**Gunnedah Waste Facility (SSD-8530563)
Response to Submissions**

ATTACHMENT 1

PROJECT NO. P1907434
												PLANSET NO. PS01
												RELEASE NO. R16
												DRAWING NO. PS01-A300
												REVISION L

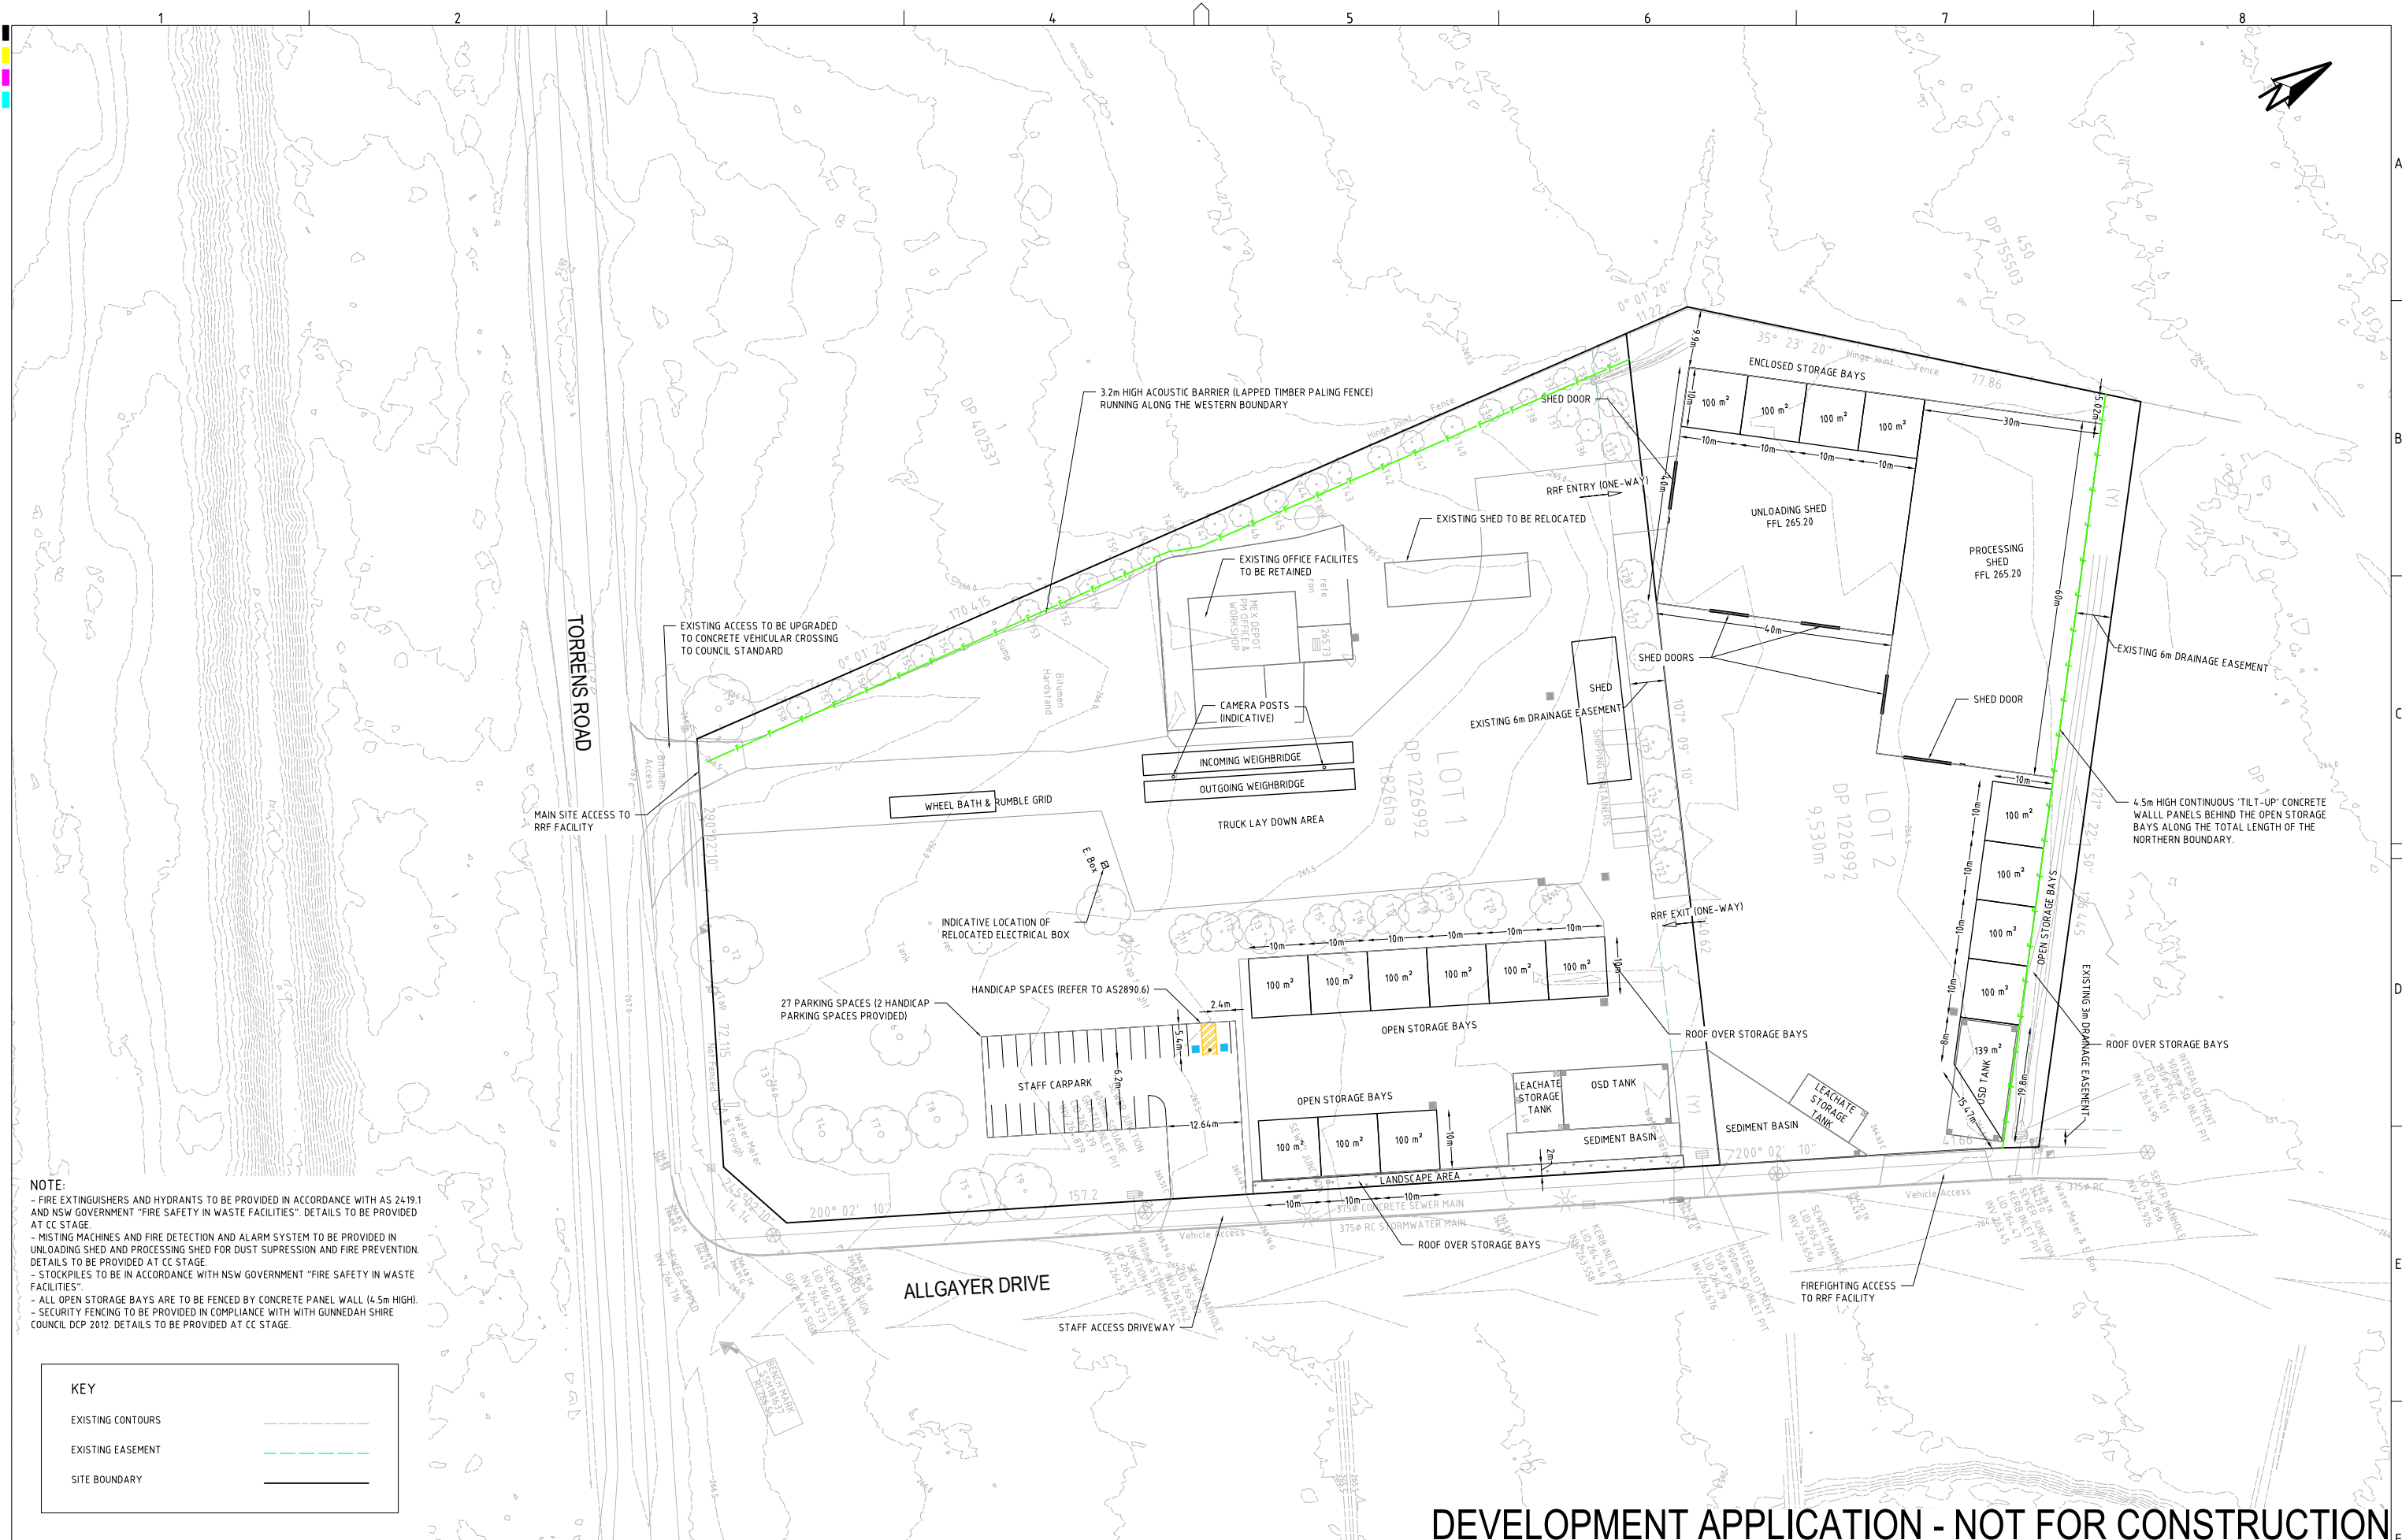
- Plans show the height of the open storage bays as 4.5m with the indicative stockpile height as 3.5m. However, the EIS describes stockpiles as being less than 4m. To comply with the Fire Safety Guideline the stockpiles must be 1m below the height of the wall.
- Provide a stockpile management plan including details of the location of all proposed stockpiles, their height and an indication of the type of waste or product to be stored. The plan should include internal and external stockpiles and should clearly show there is suitable access for firefighting equipment.

DRAWING TITLE				
UNLOADING AND PROCESSING SHED PLAN				
PROJECT NO.	PLANSET NO.	RELEASE NO.	DRAWING NO.	REVISION
P1907434	PS01	R16	PS01-A310	F

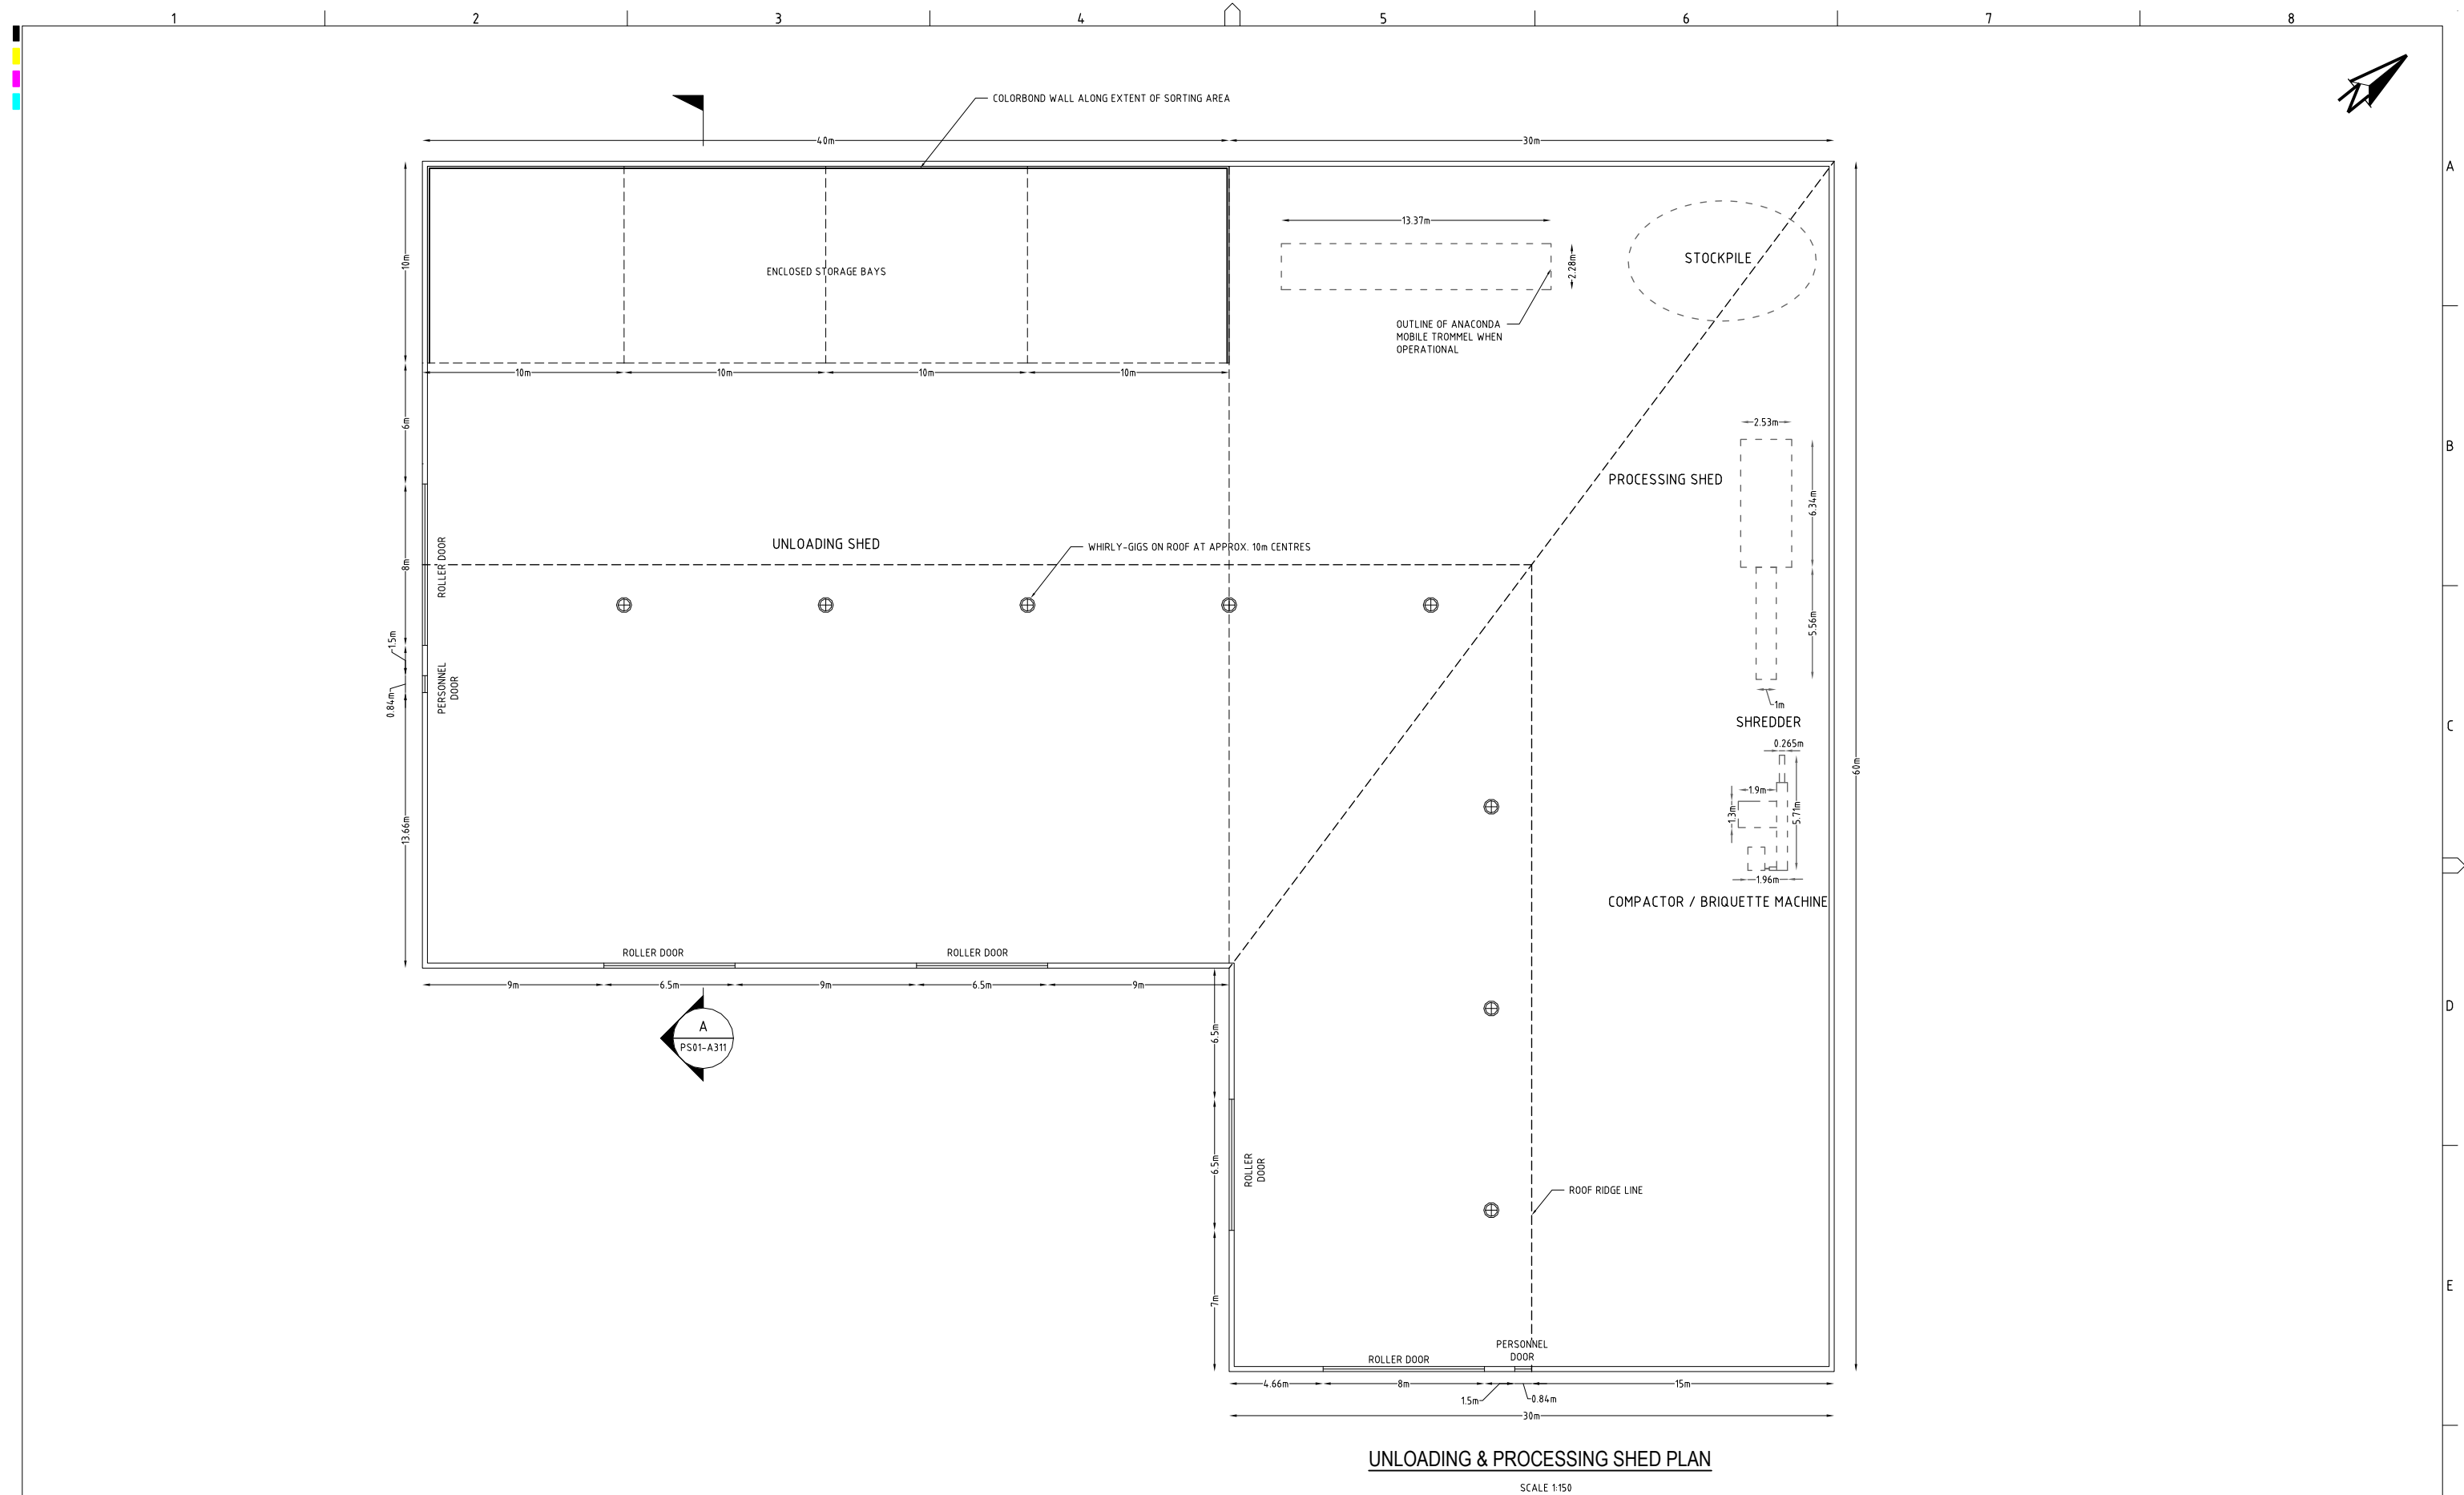
- Confirm and show on a plan the processes to be carried out in the processing shed e.g. shredding, crushing, screening. For excavated and C&D material the EIS states this would be shredded. Please confirm why excavated/C&D waste needs to be shredded.

- The EIS states excavated material and C&D waste products would be moved to storage bins. These are not shown on any plan. Please confirm the location of the storage bins and if this is a reference to storage bays, please indicate which bays.
